# CITY OF ALBUQUERQUE

**Re: Calvary Christian Academy Gym**  
**12820 Indian School NE**  
**Traffic Circulation Layout**  
Engineer's/Architect's Stamp **5-4-16** (J22-027A)

Based upon the information provided in your submittal received 5-4-16, the above referenced plan cannot be approved for Building Permit until the following comments are addressed:

REVISION DATE
DATE 05-4-2016
SHEET NUMBER TCL-1

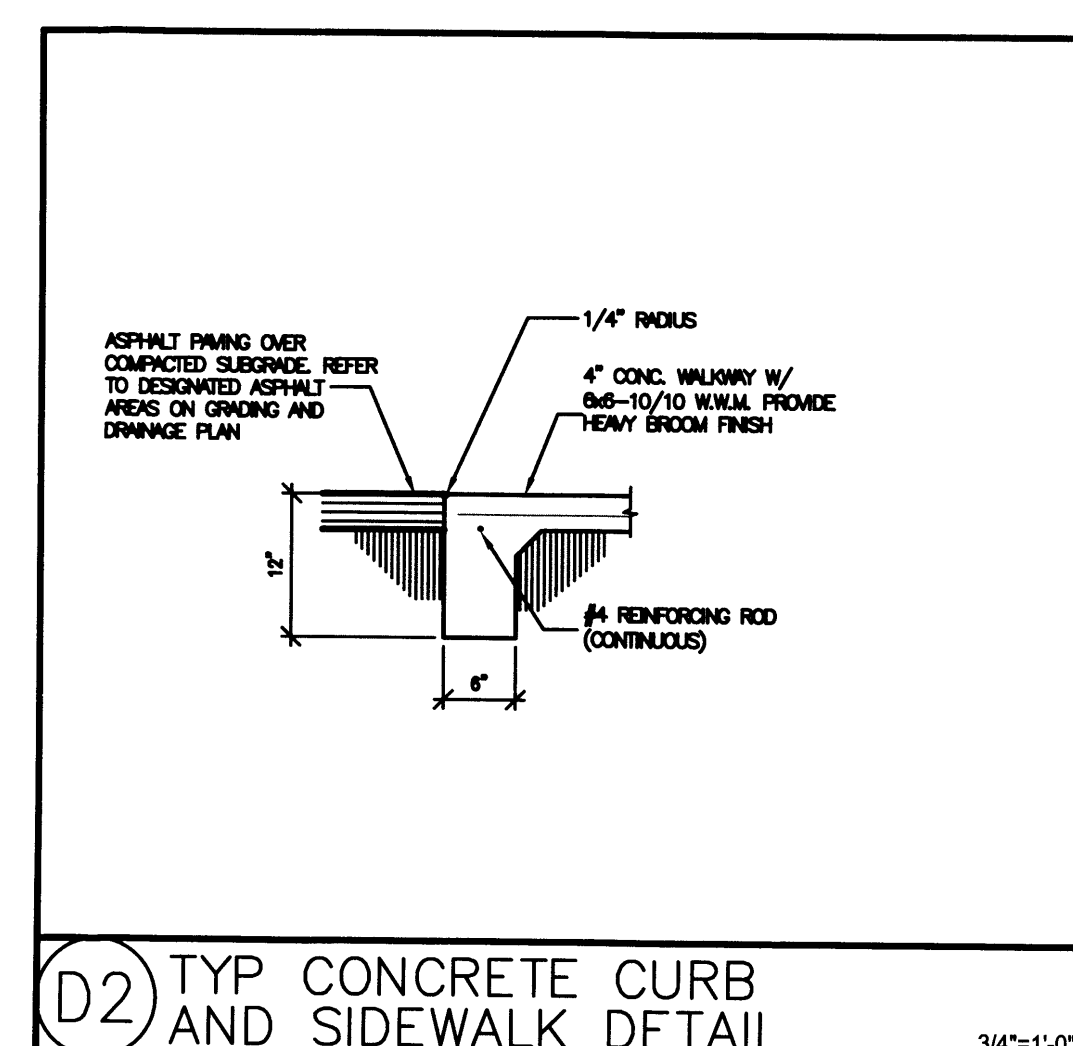
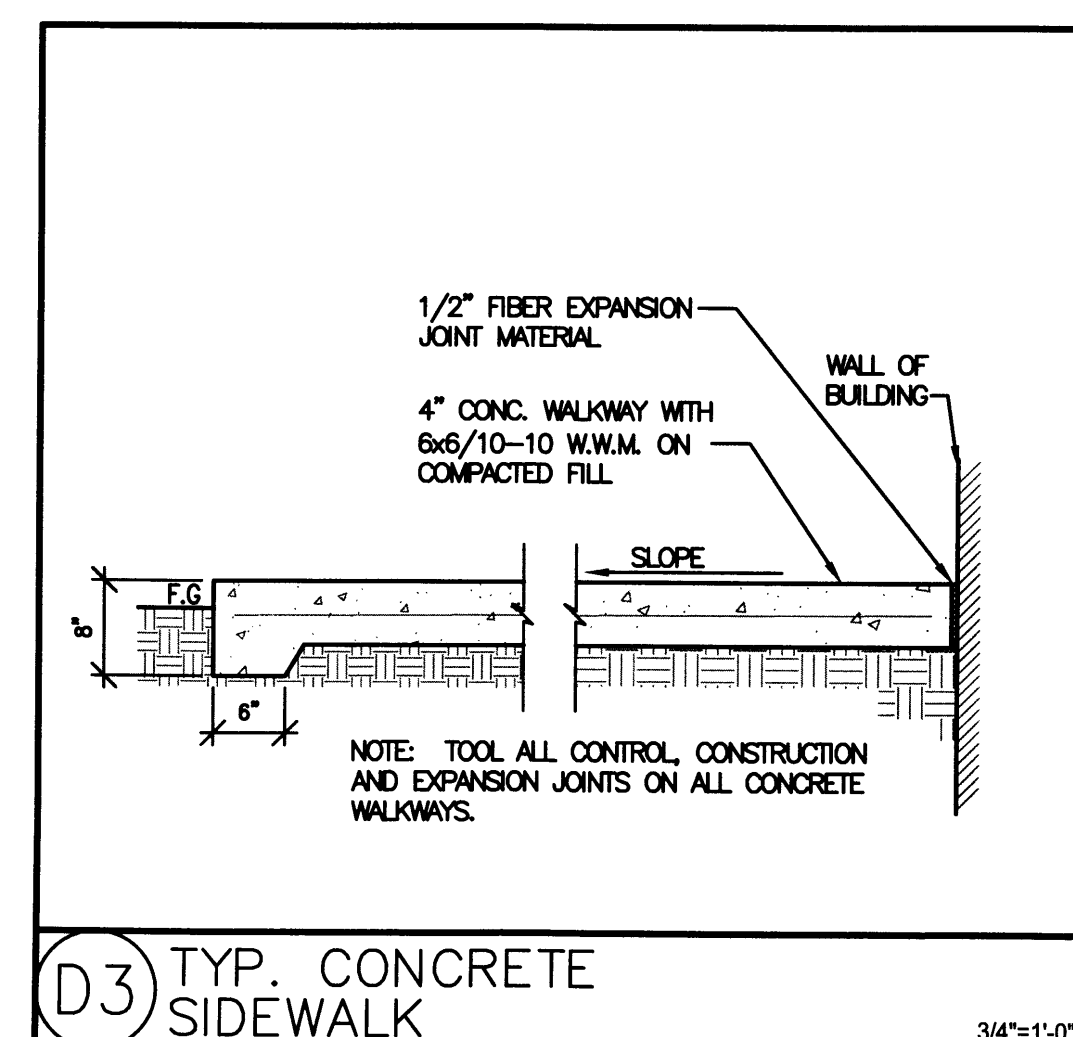
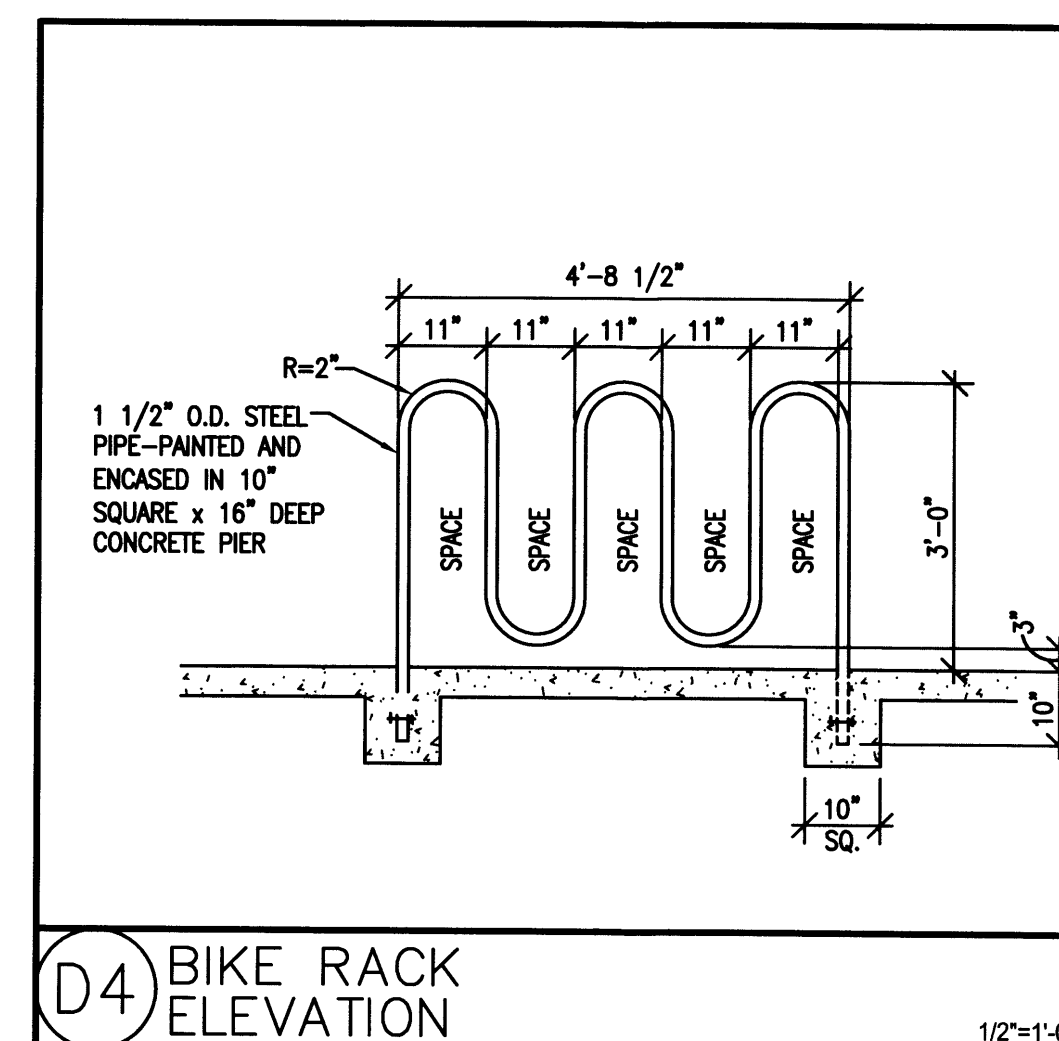
1. Please review and revise plan to provide all information listed on the attached Traffic Circulation Layout Check List.
2. List the number of parking spaces required by the zoning code as well as the proposed number of parking spaces. Please state the number of parking spaces being removed by the building addition.

3. Clarify the extents of the current phase.
4. Please identify all existing buildings, doors, structures, sidewalks, ADA ramps, curbs, drive pads, walls and anything that influences the parking and circulation on the site.

5. Please list the width and length for all existing and proposed parking spaces.
6. The handicap accessible spaces must include an 8 ft. wide van access aisle; all other aisles should be 5 ft. in width.

7. The ADA accessible parking sign must have the required language per 66-7-352.4C NMSA 1978 **"Violators Are Subject to a Fine and/or Towing."** Please call out detail and location of HC signs. Please show this detail.

8. The ADA access aisles shall have the words **"NO PARKING"** in capital letters, each of which shall be at least one foot high and at least two inches wide, placed at the rear of the parking space so as to be close to where an adjacent vehicle's rear tire would be placed. (66-1-4.1.B NMSA 1978)

9. Show all drive aisle widths and radii.
10. Per DPM, a 6 ft. wide ADA accessible pedestrian pathway is required from the public sidewalk to the building entrances. Please clearly show this pathway and provide details from Indian School Rd.

11. Per DPM, a 6 ft. wide ADA accessible pedestrian pathway is required from the HC parking stall access aisles to the building entrances. Please clearly show this pathway and provide details. Clearly show the proposed new configuration of the ADA HC parking spaces.

12. Provide a min 6" or max 8" high concrete barrier curb or other acceptable barrier between landscaping and parking areas and/or drive aisles. Please call out detail and location of barrier curb.

13. Design delivery vehicle route needs to be shown.
14. Service vehicle and/or refuse vehicle maneuvering must be contained on-site; provide a copy of refuse approval.

15. Please provide a sight distance exhibit (see the *Development Process Manual, Chapter 23, Section 3*).
16. Please add the following note to the clear sight triangle: "Landscaping and signage will not interfere with clear sight requirements. Therefore, signs, walls, trees, and shrubbery between 3 and 8 feet tall (as measured from the gutter pan) will not be acceptable in this area."

17. All broken or cracked sidewalk must be replaced with sidewalk and curb & gutter. A build note must be provided referring to the appropriate City Standard drawing.
